From: Hornby, Mark [Mark.Hornby@lancashire.gov.uk]
Sent: 17 October 2011 15:21
To: Graeme Thorpe
Subject: FW: Consultation on planning application 3/2011/0654 41 Dilworth Lane, Longridge - detached triple garage with office space above

The plans submitted do not detail an adequate visibility splay at the existing access point which is intended to be used for the proposed triple garage. Pre-application discussions established that a minimum 2.4 metre x 50 metre visibility splay would be required in both directions at the access point and this has not been achieved. I would therefore recommend a refusal of the application as it stands on highway safety grounds.

Fig 20. Plan of proposed garage, indicating unobstructed view towards oncoming traffic.

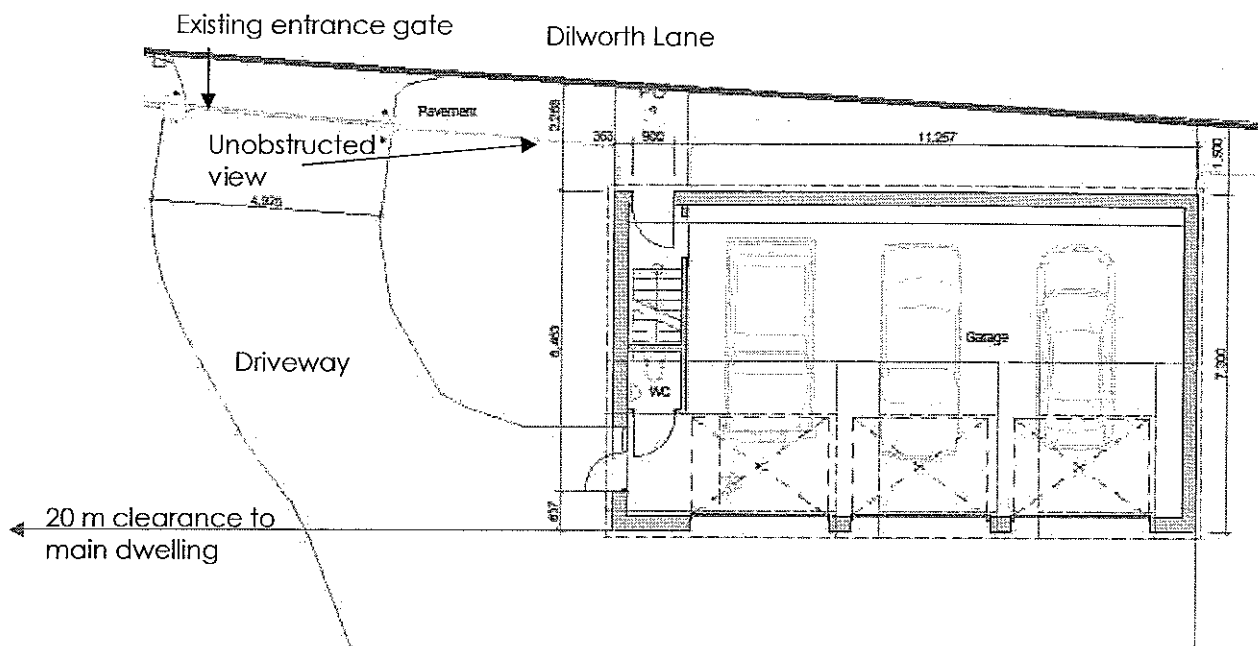
Notwithstanding the above I feel that an adequate visibility splay could be achieved with the removal of a number of trees on the highway frontage of the plot and the lowering of the existing stone wall to the western highway frontage to a maximum height of 1 metre. The provision of a continuous footway along the frontage of the plot was also discussed at pre-application stage and would improve both visibility and pedestrian accessibility. Although a footway is shown on either side of the access point it is not clear from the submitted drawings how far this extends to the east past the proposed garage.
